**Consultation Response from KC,
Highways Development Management**

2025/93449 Land east of, Abbey Road North, Shepley, Huddersfield, HD8 8FG

Discharge of details reserved by conditions 27 (crime prevention), 29 (boundary treatments), 30 (external lighting) and 31 (landscaping) of previous permission 2024/90991 for variation of conditions 2 (plans) and 28 (materials) of previous permission 2020/93358 for erection of 52 dwellings

Date Responded: 21/05/2026

Drawing Title:
FLEX MSE PLAN & ELEVATION

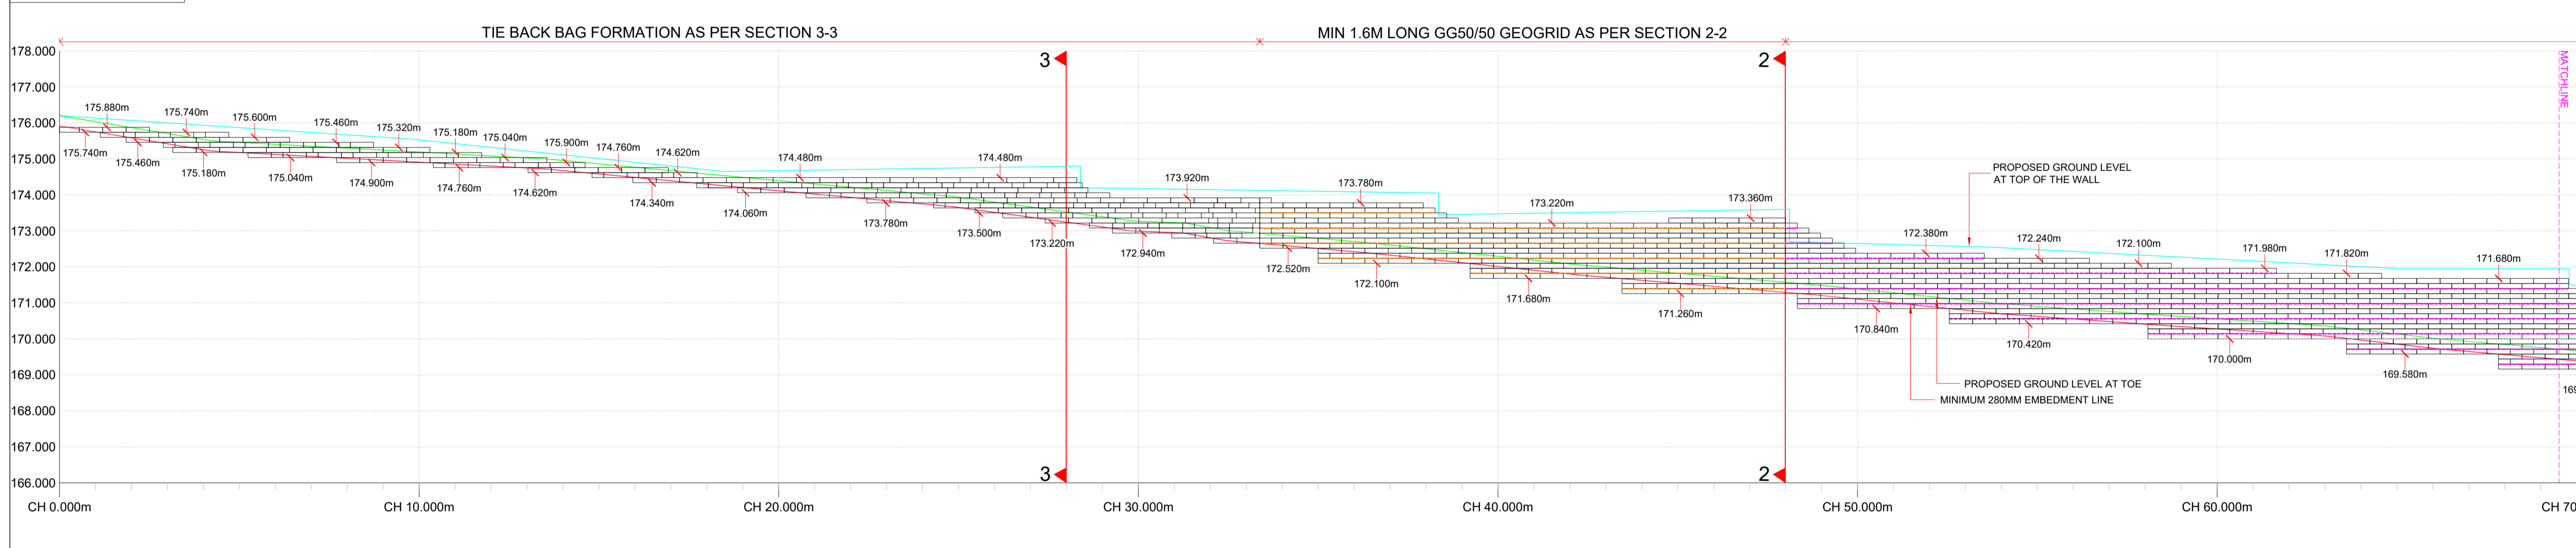
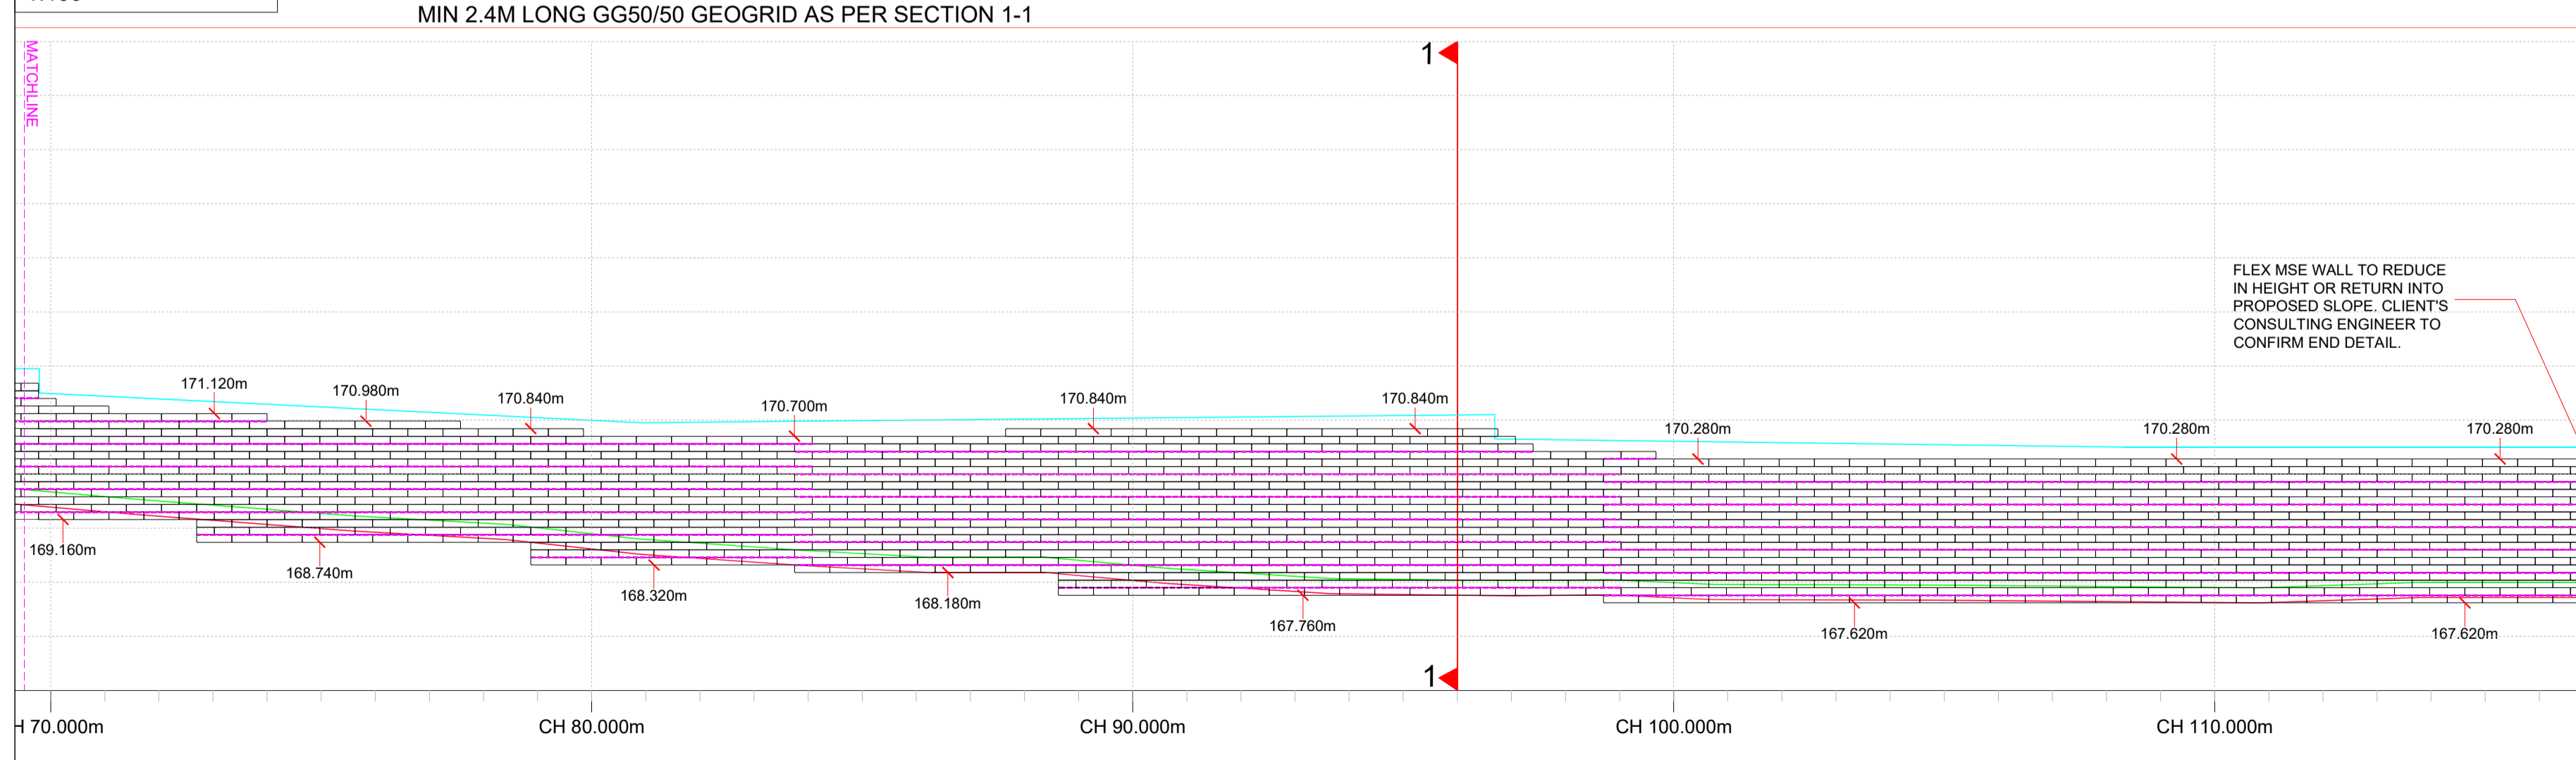
It is noted that The Knowle has an existing low stone wall and vegetation on the inside of the bend and it is expected that this existing would have more of an impact on forward visibility than the proposed retaining wall structure that is to be set back behind the stone wall and existing post and wire fence. We would expect that if the post and wire fence and the vegetation were removed then the visibility around the bend before it would be impacted by the new retaining wall would be up to 22m, possibly greater, and this would take the maximum speeds up to approximately 18mph.

With these low speeds and the expected low vehicular use we would not consider that the forward visibility will be adversely impacted by the proposed retaining wall and we can support the discharge of condition 29.

TITLE: **FORWARD VISIBILITY SPLAY
THE KNOWLE**

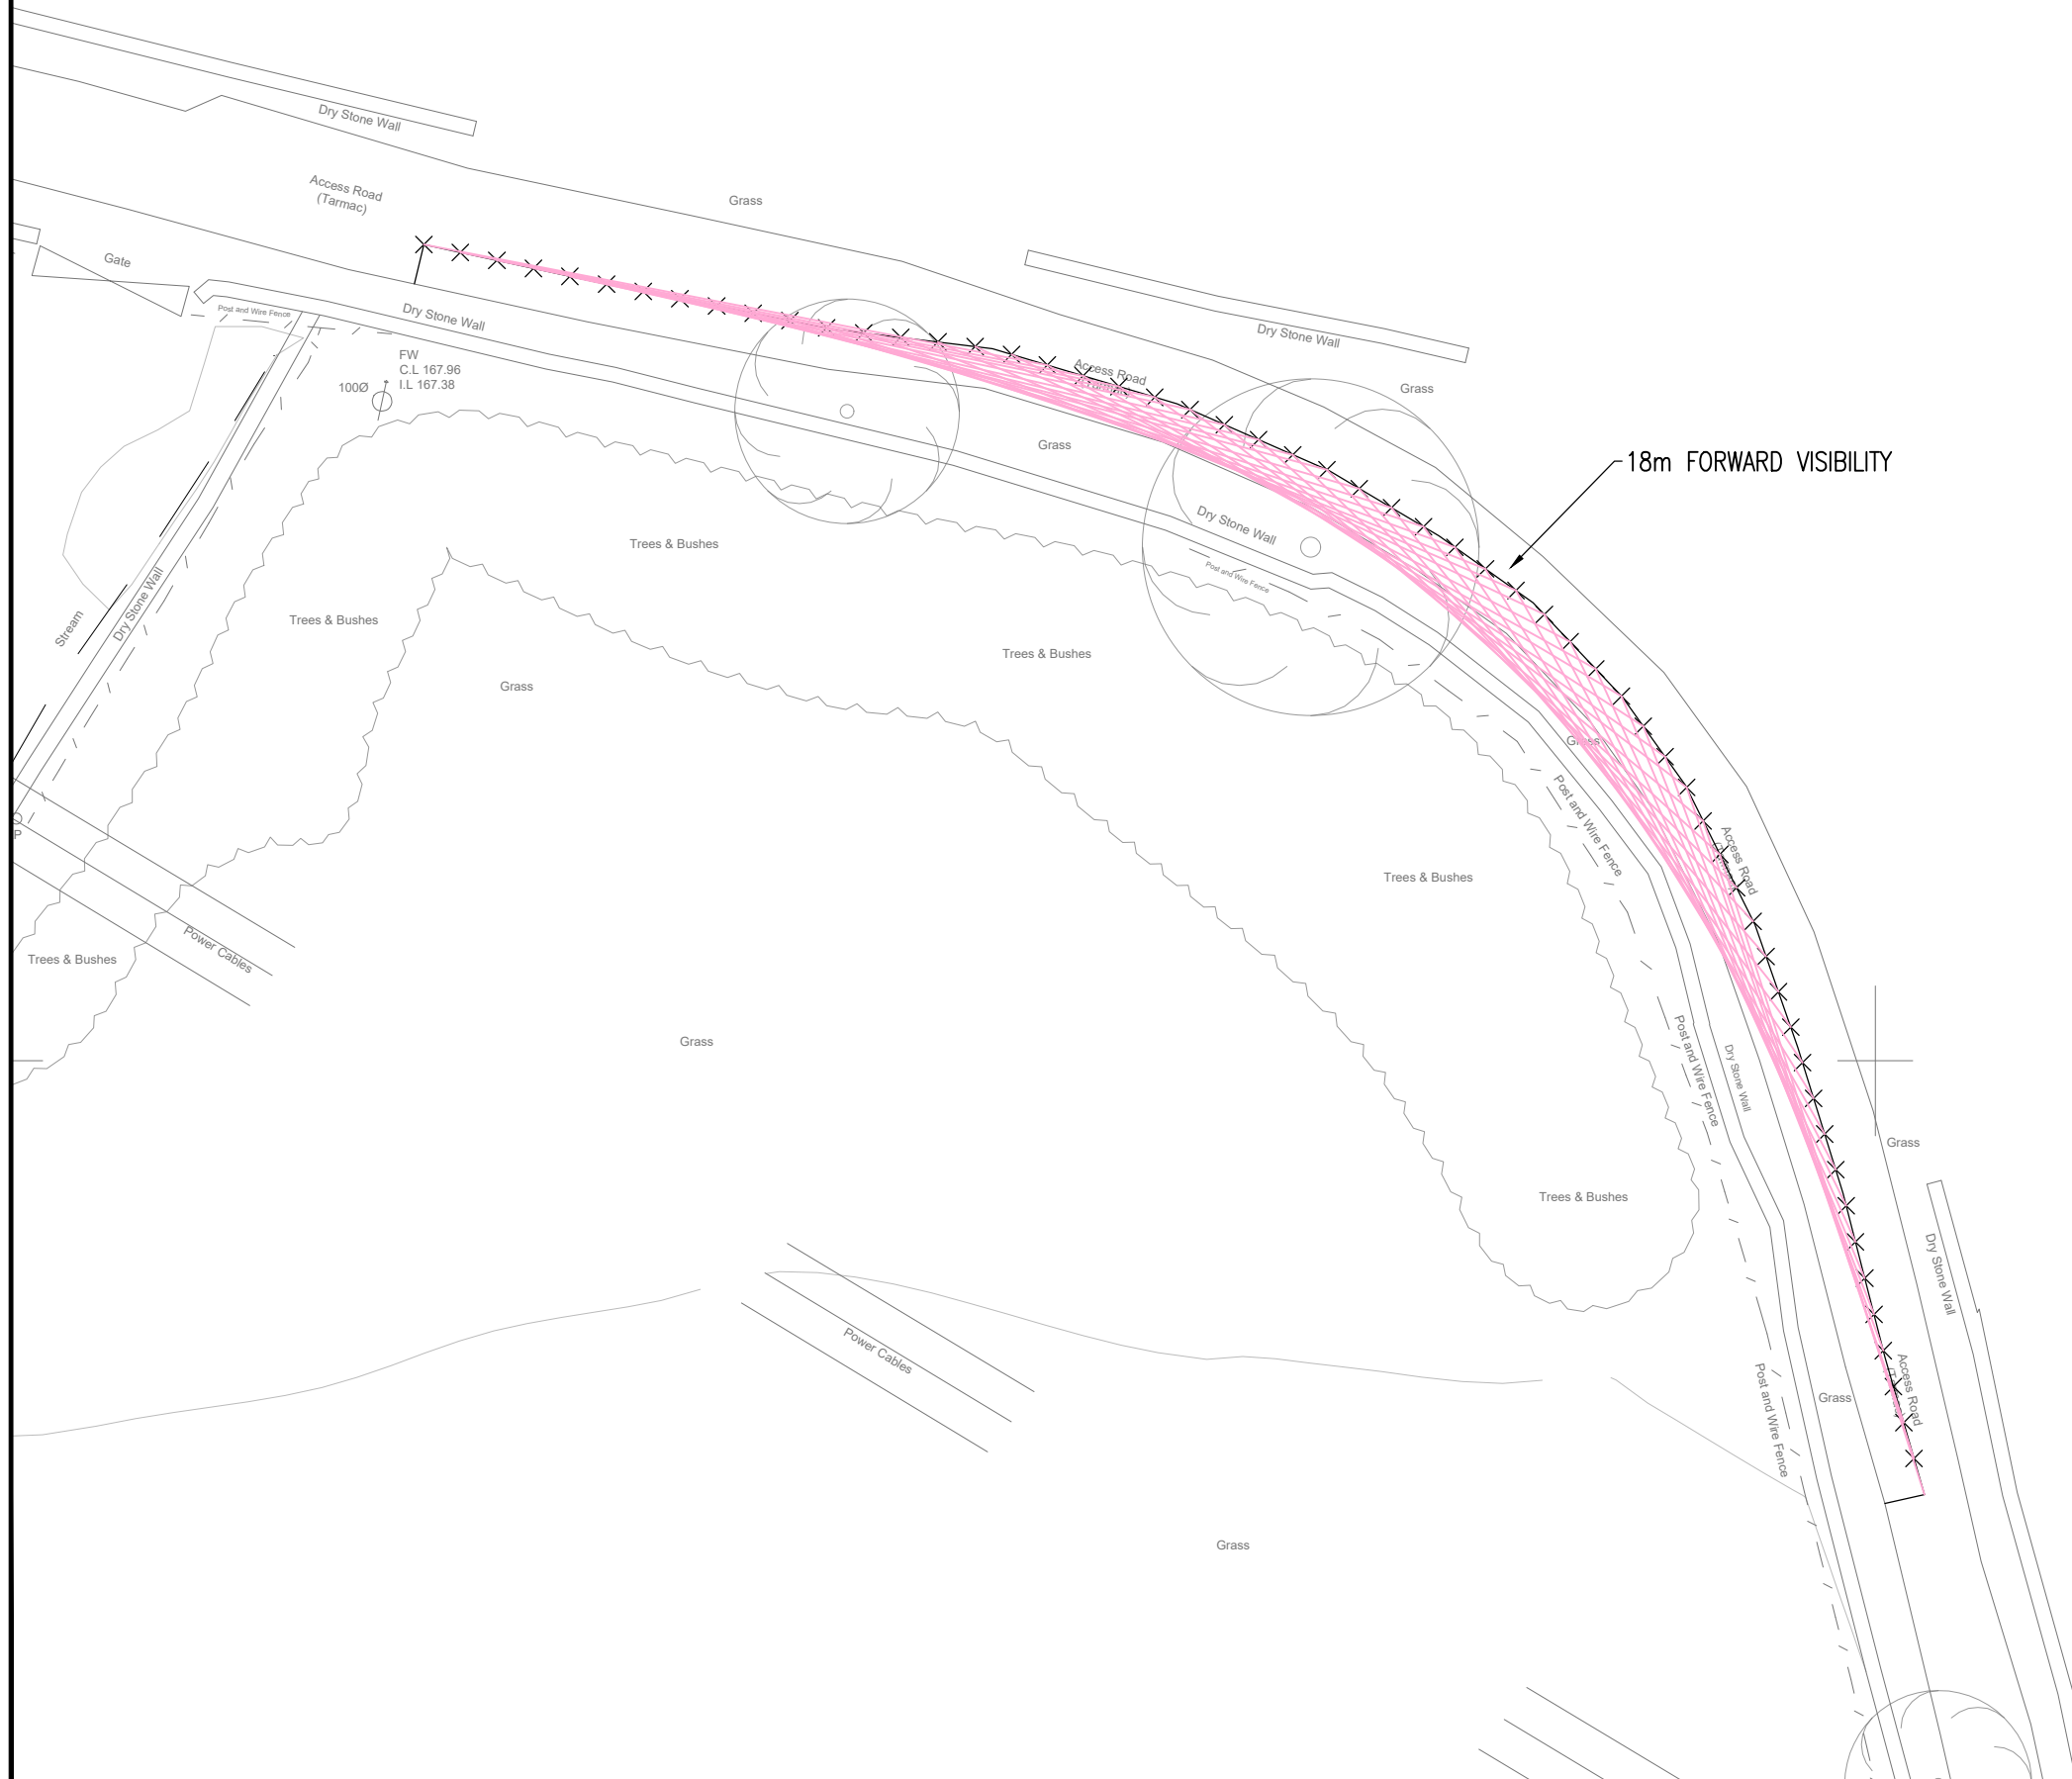
Within the submissions by the applicant for the discharge of condition 29 was drawing No 2604 101 Rev P01 Forward Visibility Splay The Knowle. This indicates that an 18m forward visibility can be achieved around the bend on The Knowle and using Manual for Streets forward visibility calculations this would be suitable for vehicle speeds of up to 15mph.

No speed surveys were provided by the applicant, however due to the narrow width of The Knowle and the very sharp bend around the northern point of the site, we would not expect speeds to be much above this.
